DRB Application No.: **05DRB-01283 (P&F)**

Project # **1003982**

Project Name: **LANDS OF TAIHI & MARYANN JONES**

DEVELOPMENT REVIEW BOARD – SPEED MEMO

PLAT OF TRACT A LANDS OF TAIHI and MARYANN JONES
 WITHIN SECTION 16, TOWNSHIP 10 NORTH, RANGE 3 EAST, N.M.P.M. CITY OF ALBUQUERQUE BERNALILLO COUNTY, NEW MEXICO
 AUGUST, 2005

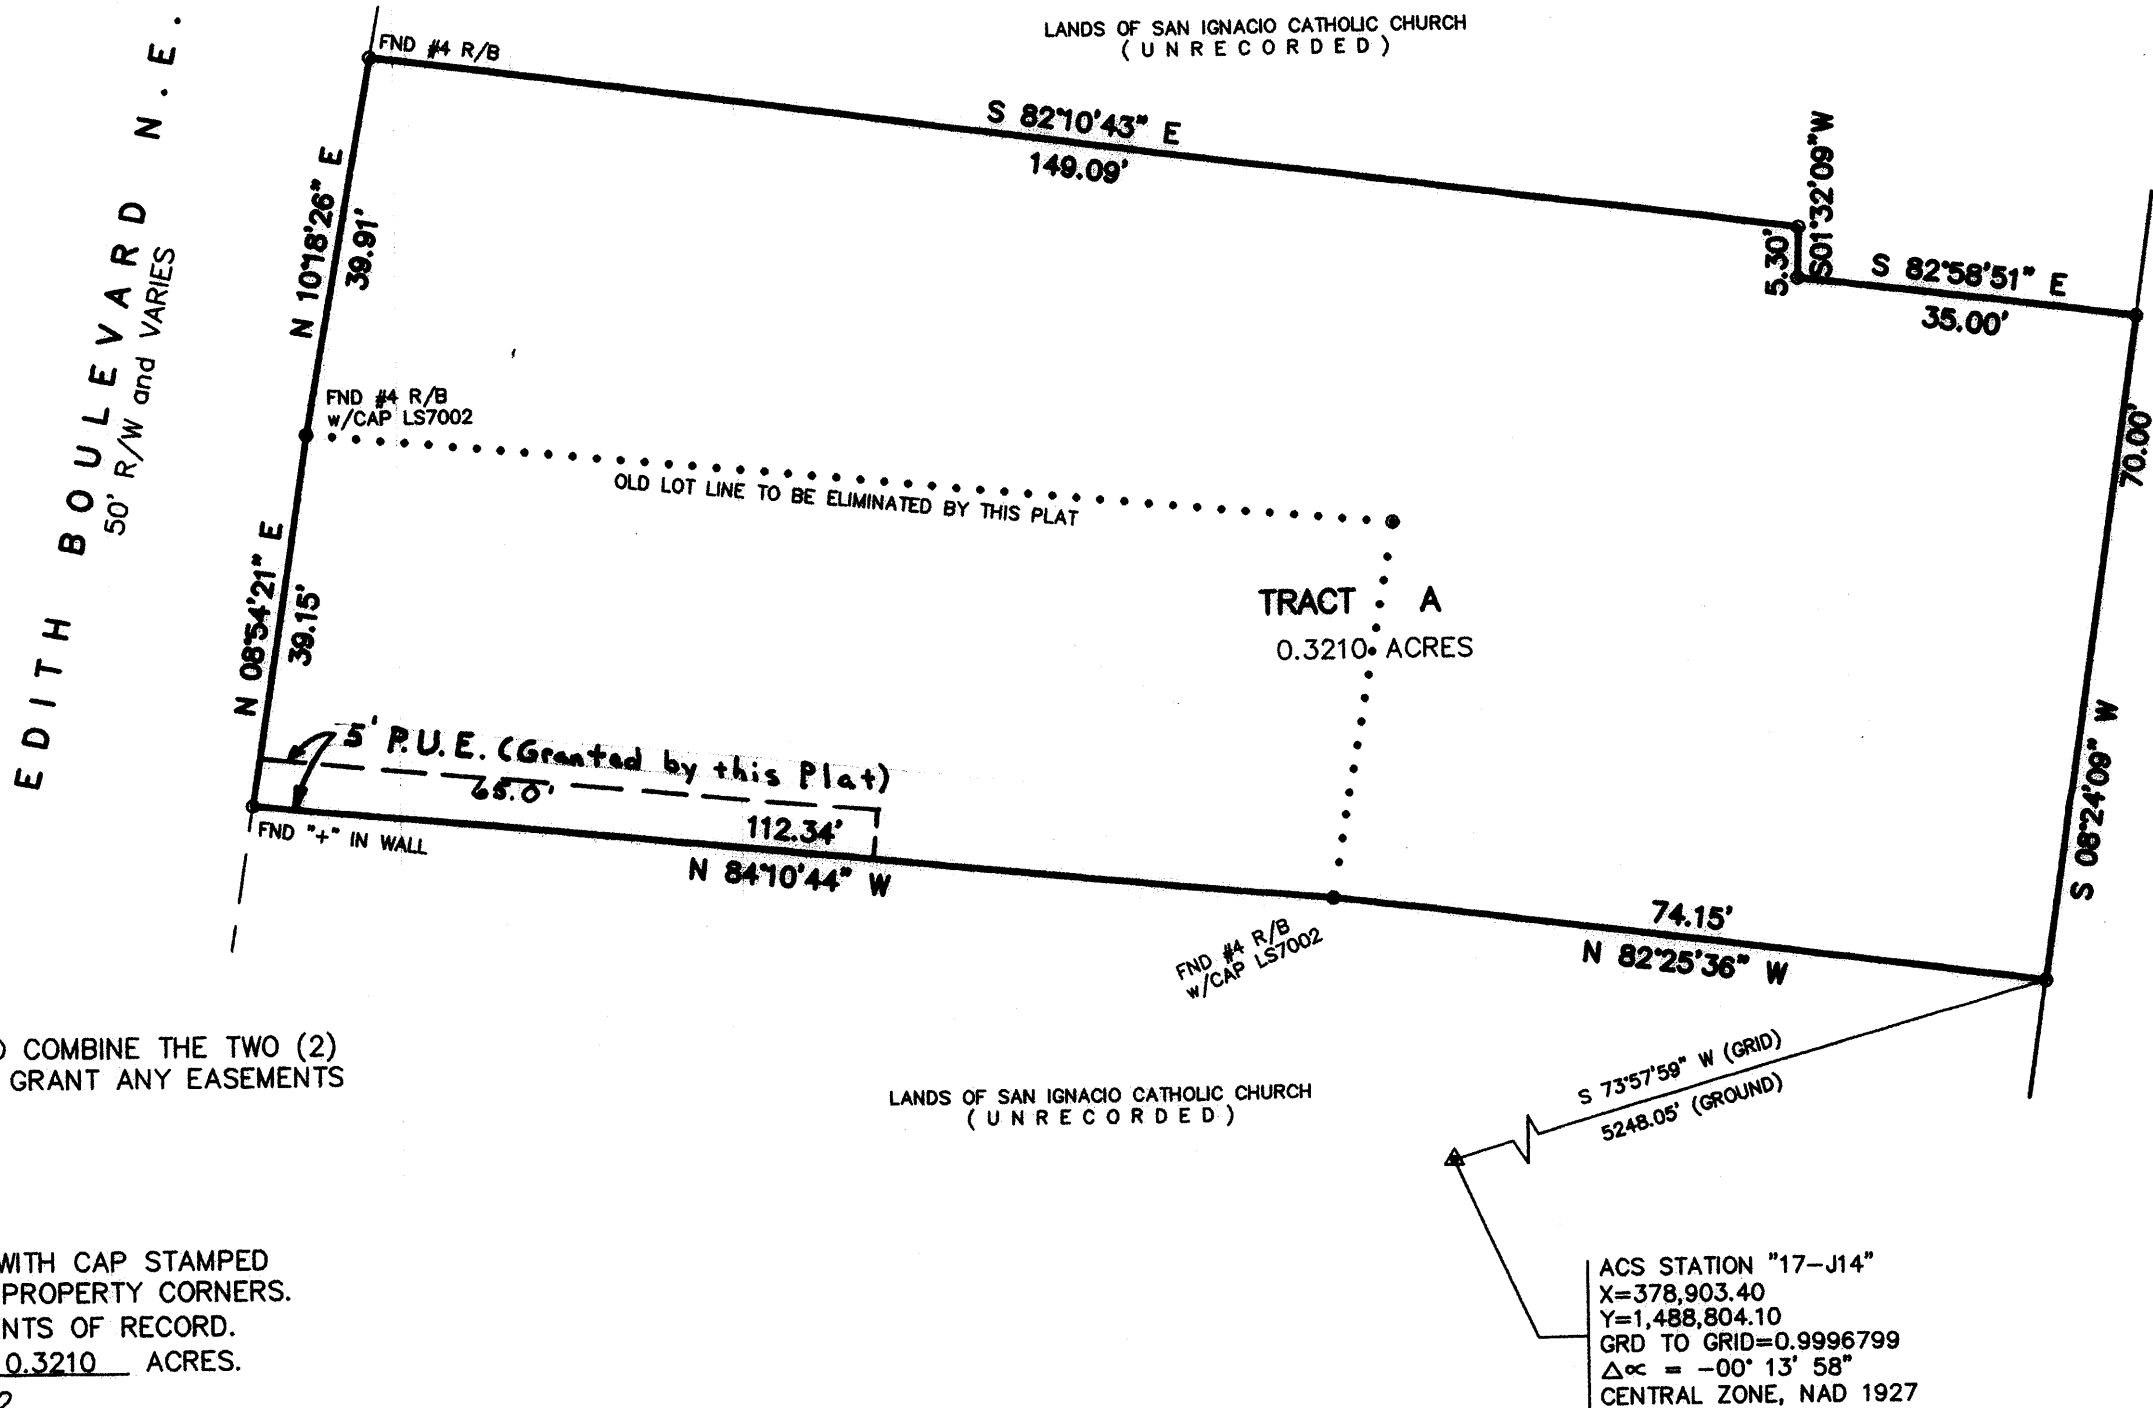
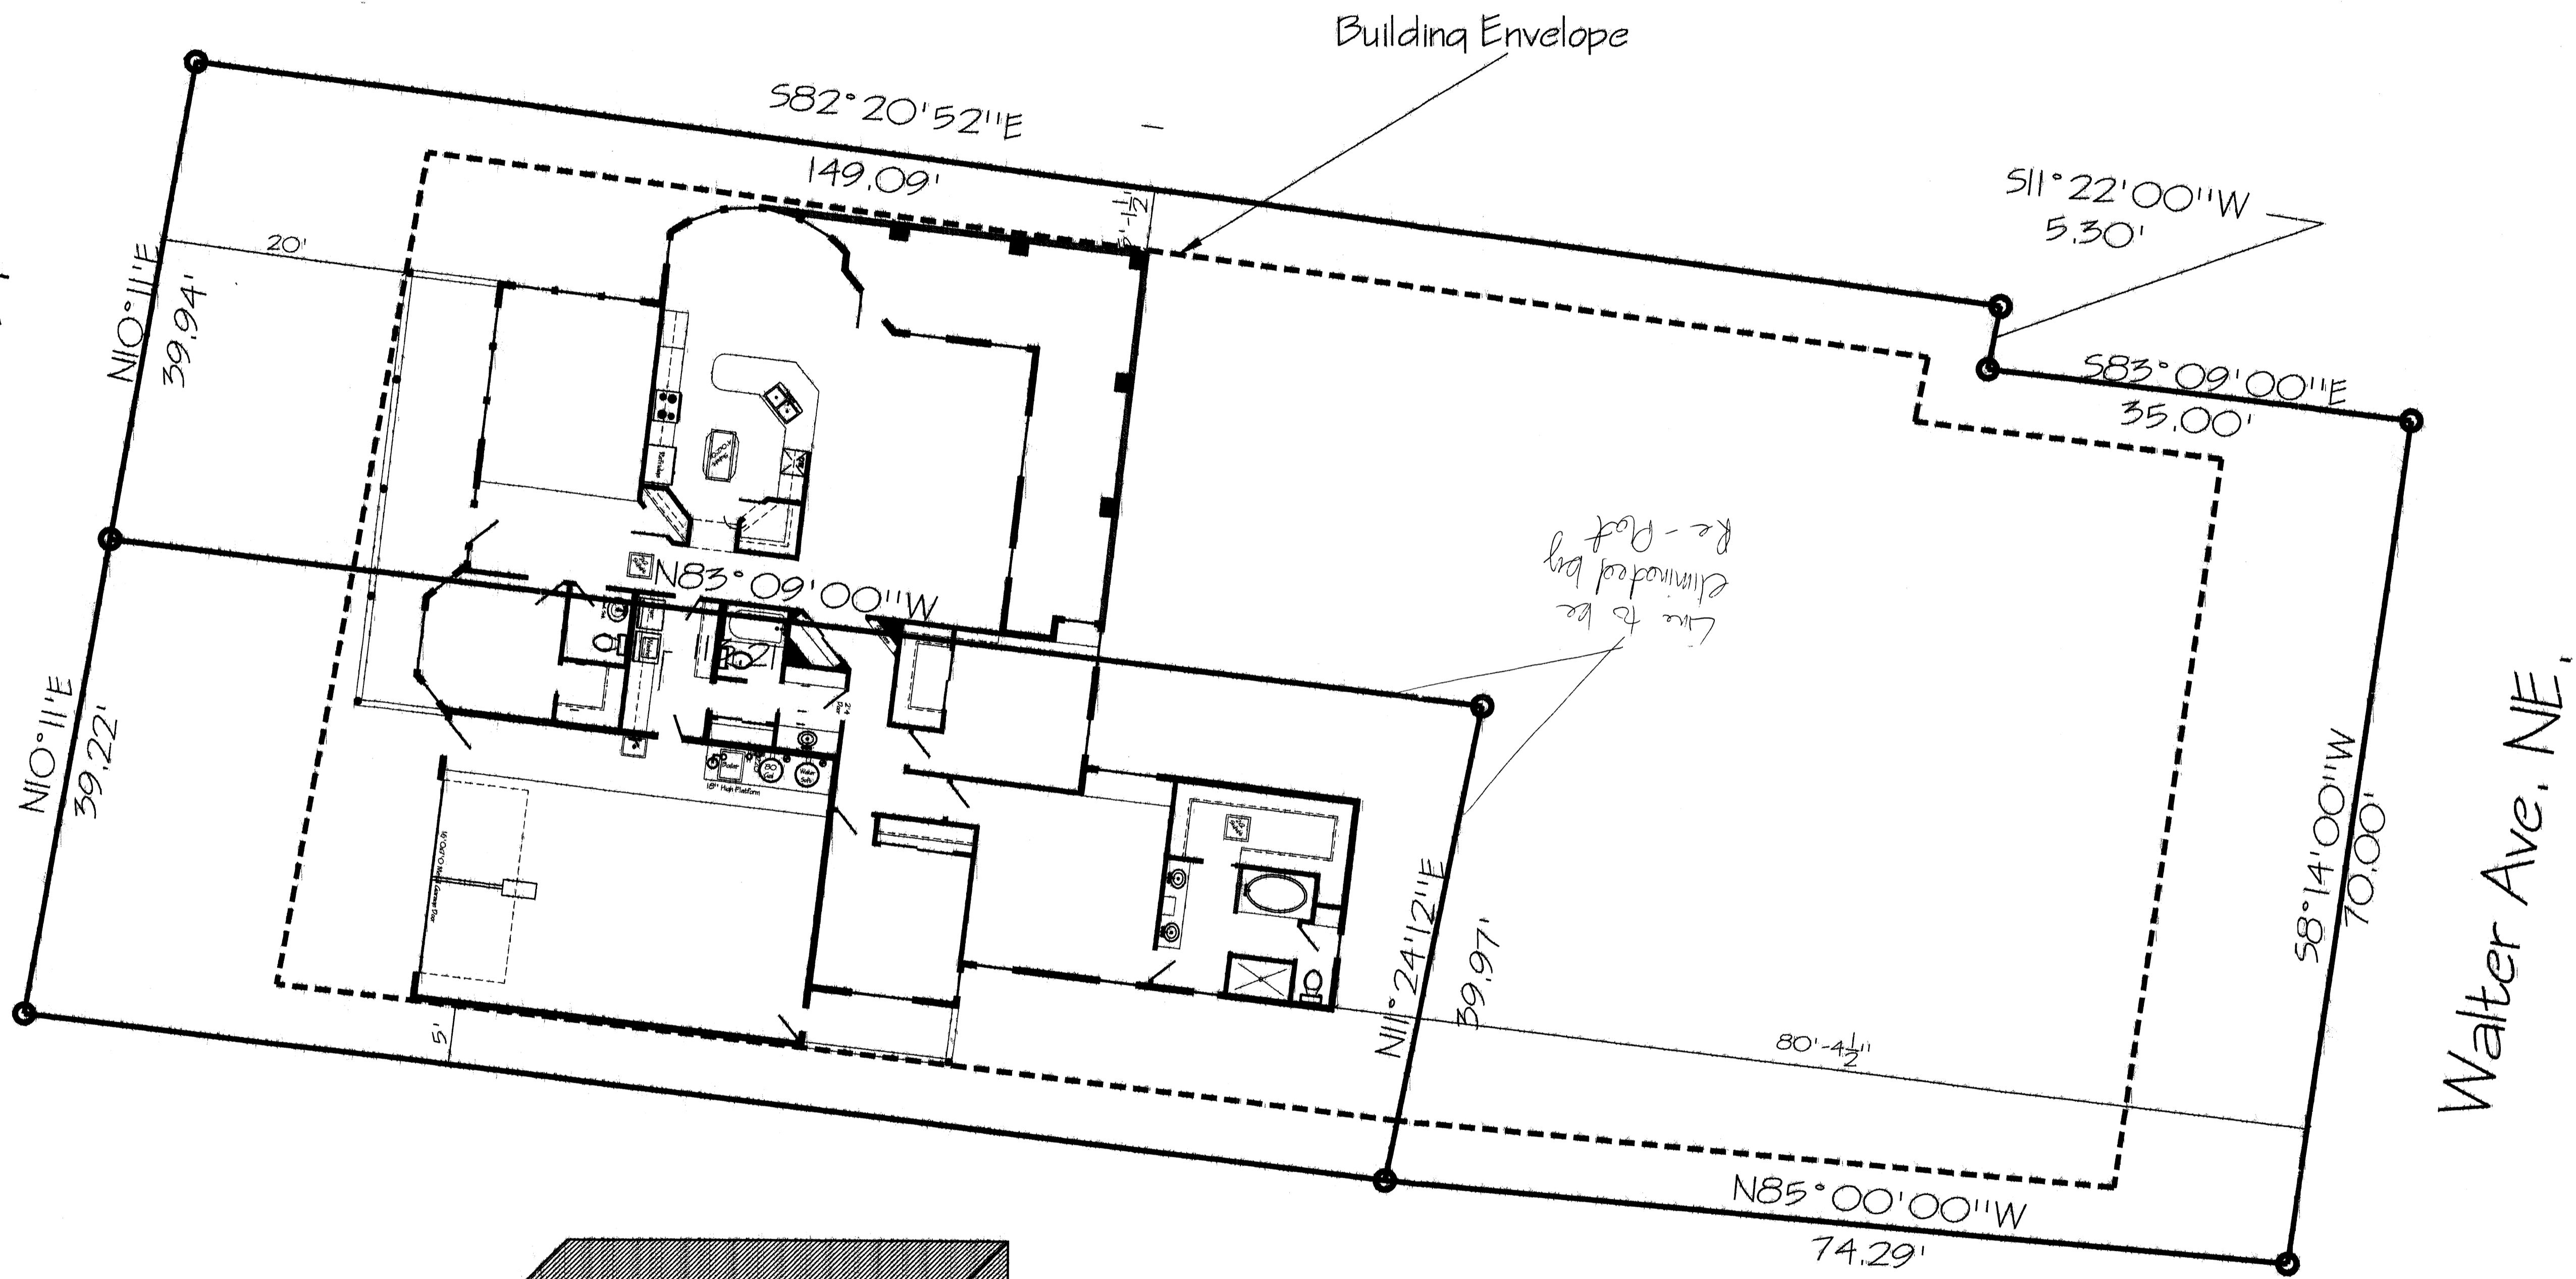
<u>No.</u>	<u>Comment</u>
1)	Need to provide sketch showing relationship of right-of-way, curb face and sidewalk location.
2)	Are the sidewalks in place?
3)	What are the right-of-way widths?
4)	Standard infrastructure per DPM required.

There appears to be an existing structure on one of the lots.

Are you going to remove the existing structure?
